STATE OF NORTH CAROLINA
DEPARTMENT OF TRANSPORTATION

Addendum No. 1

RE: Contract ID: C201226
WBS# 34459.3.4
Proposal No. 1
Johnston-Wake Counties (R-2552AA, R-2552AB)
US-70 Bypass (Clayton Bypass) From I-40
To East of NC-42.

May 17, 2005 Letting

PROJECT REFERENCE NO. R-2552AB	SHEET NO. 8
R/W SHEET NO. R-2552AA *22 & R-2552AB *8	
ROADWAY DESIGN ENGINEER	HYDRAULICS ENGINEER
PRELIMINARY PLANS DO NOT USE FOR CONSTRUCTION	
CONST. REV.	
R/W REV.

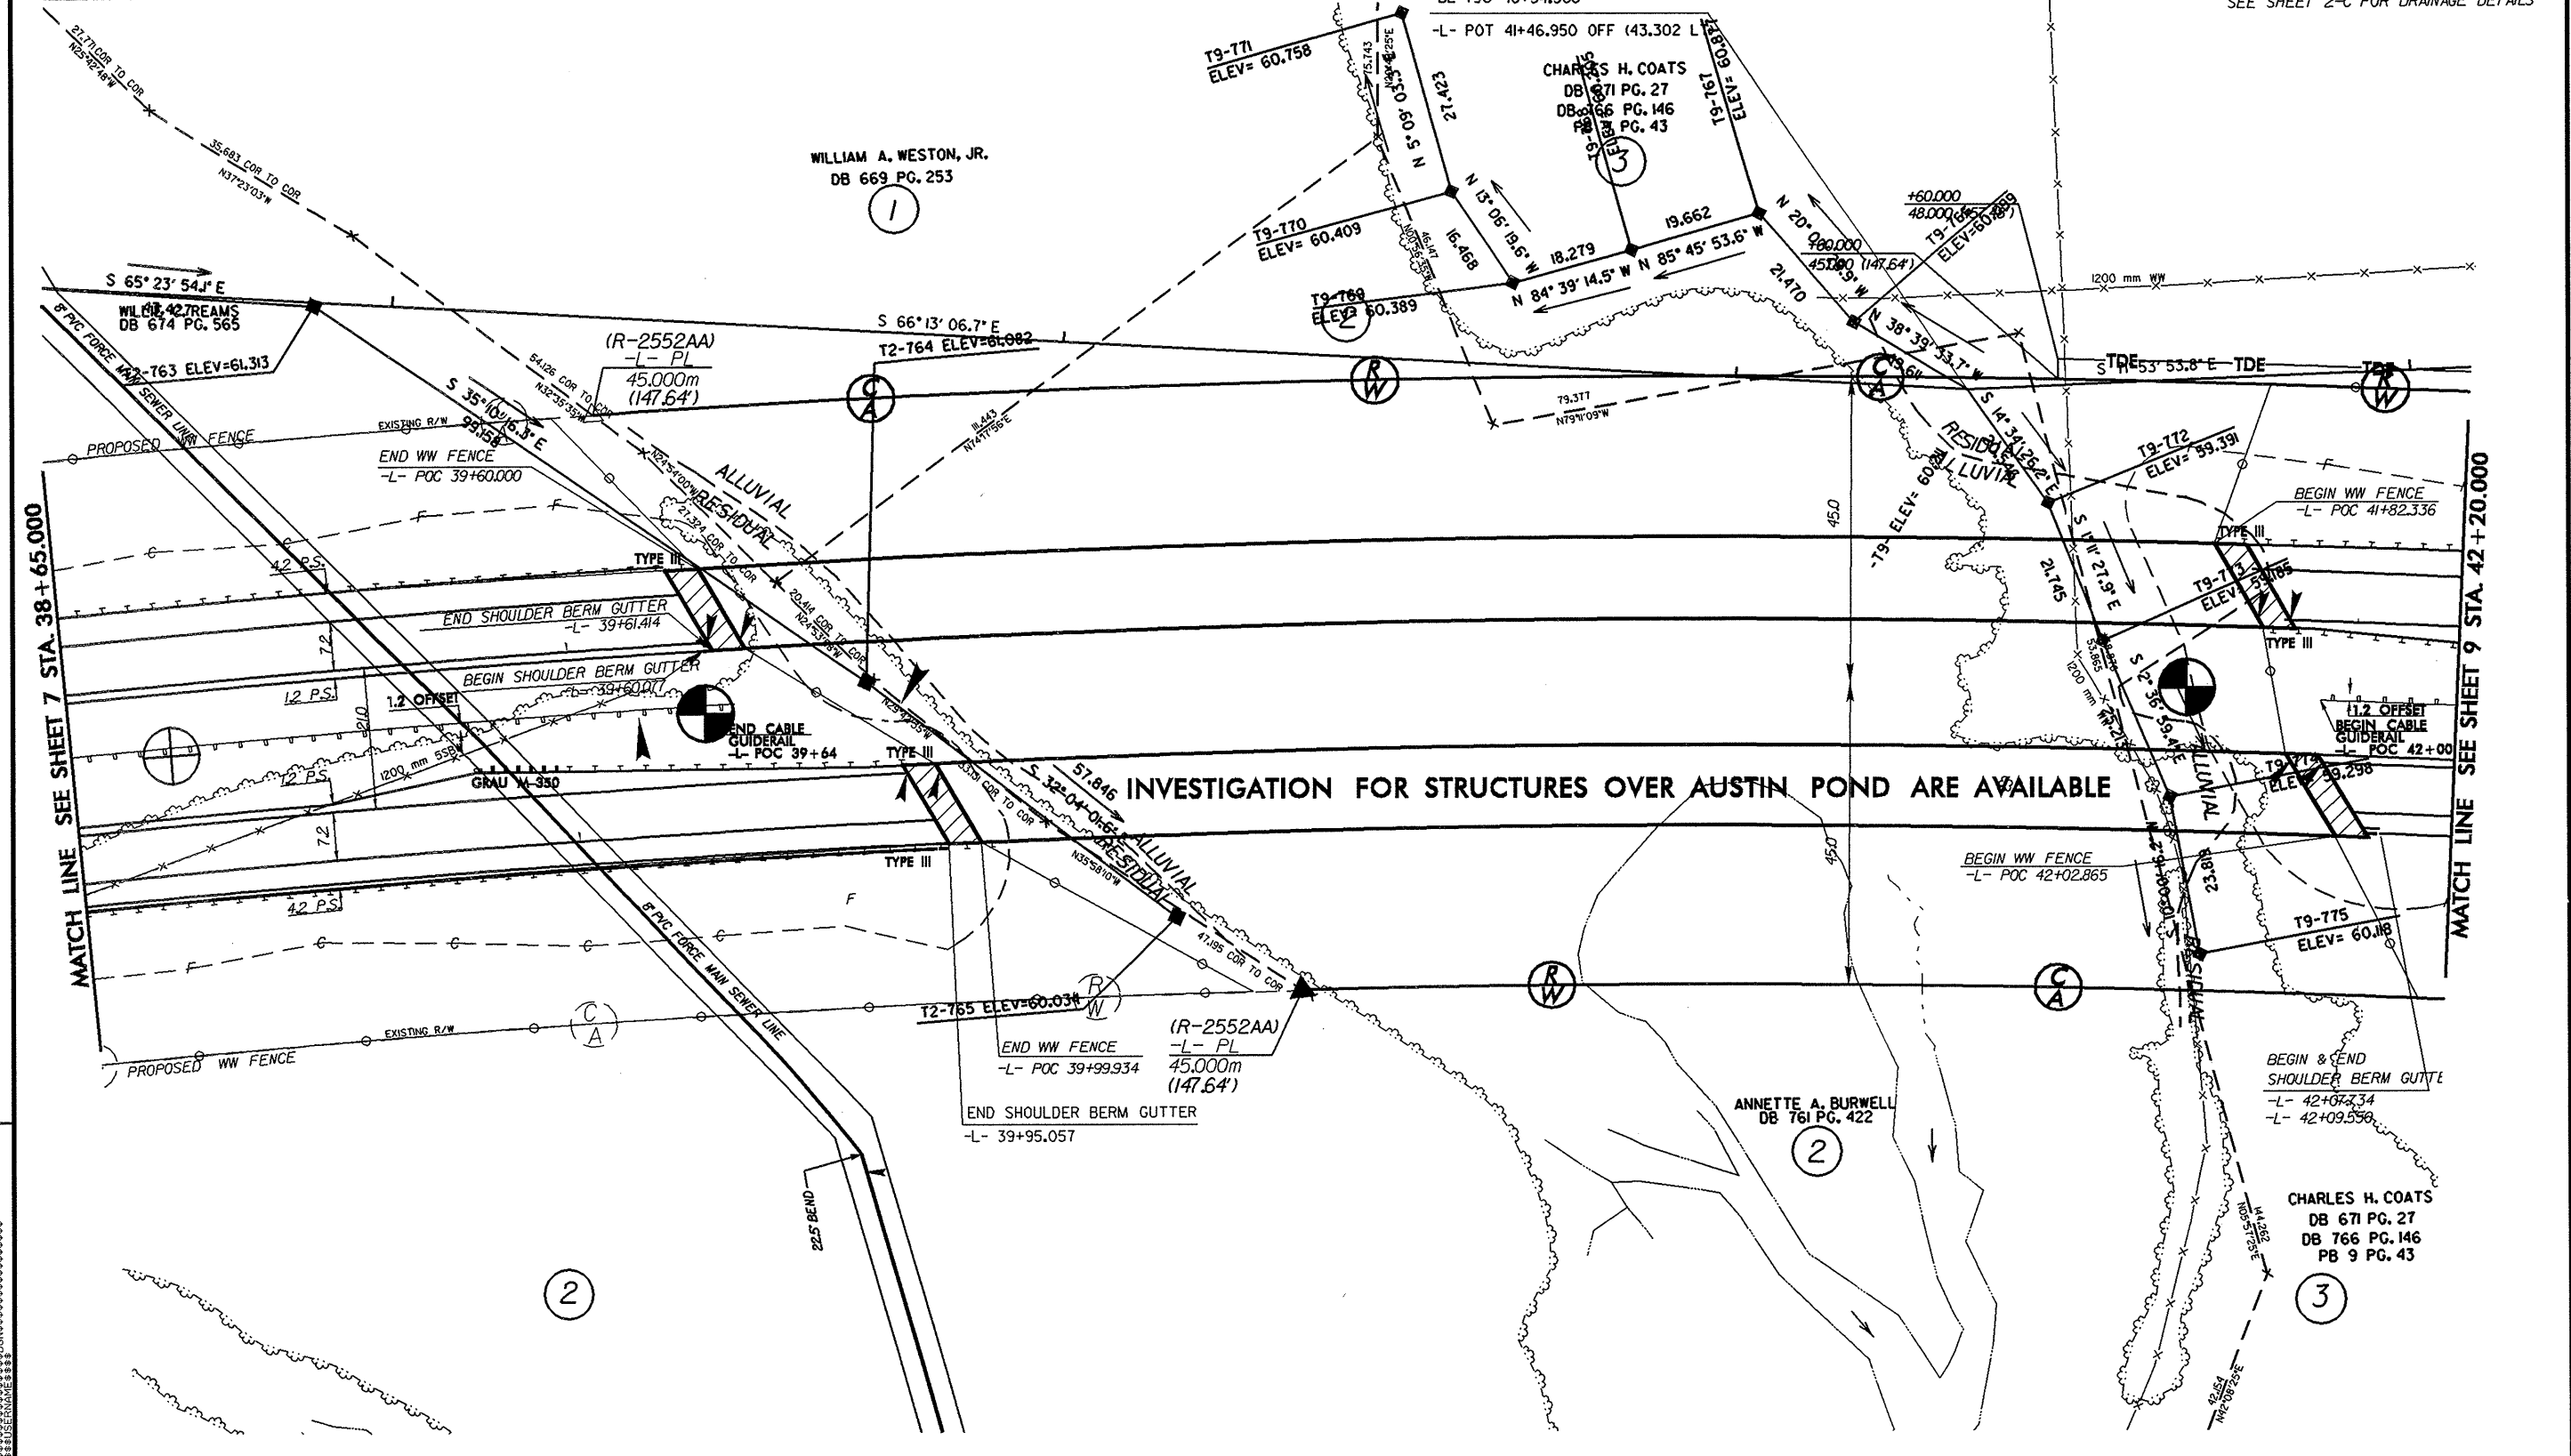
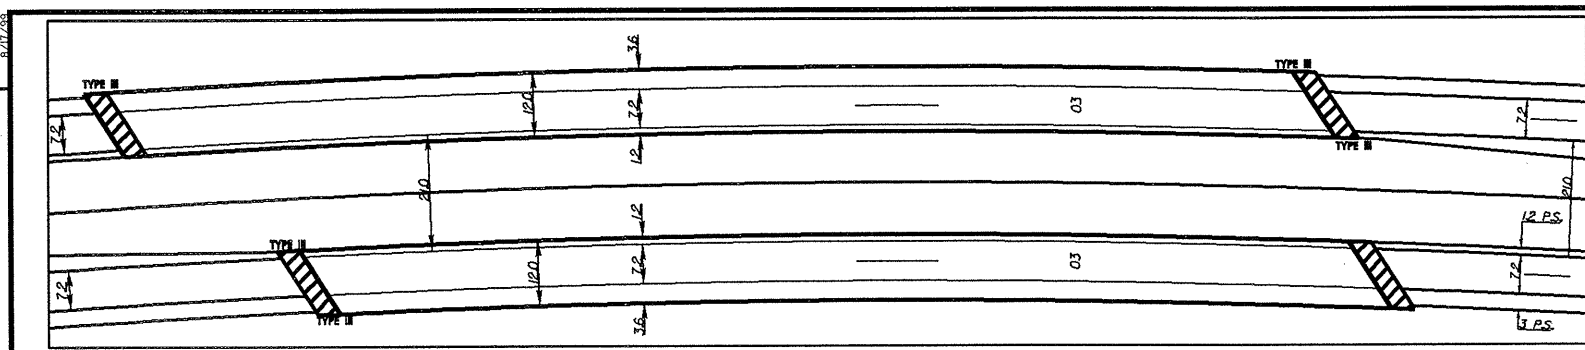
Plan Sheet Nos. 8 and 12 (R-2552AB) have been revised to remove the “DDE” quantity from the “Hazardous Spill Basins.” Please void Sheet Nos. 8 and 12 in your plans and staple the revised Sheet Nos. 8 and 12 thereto.
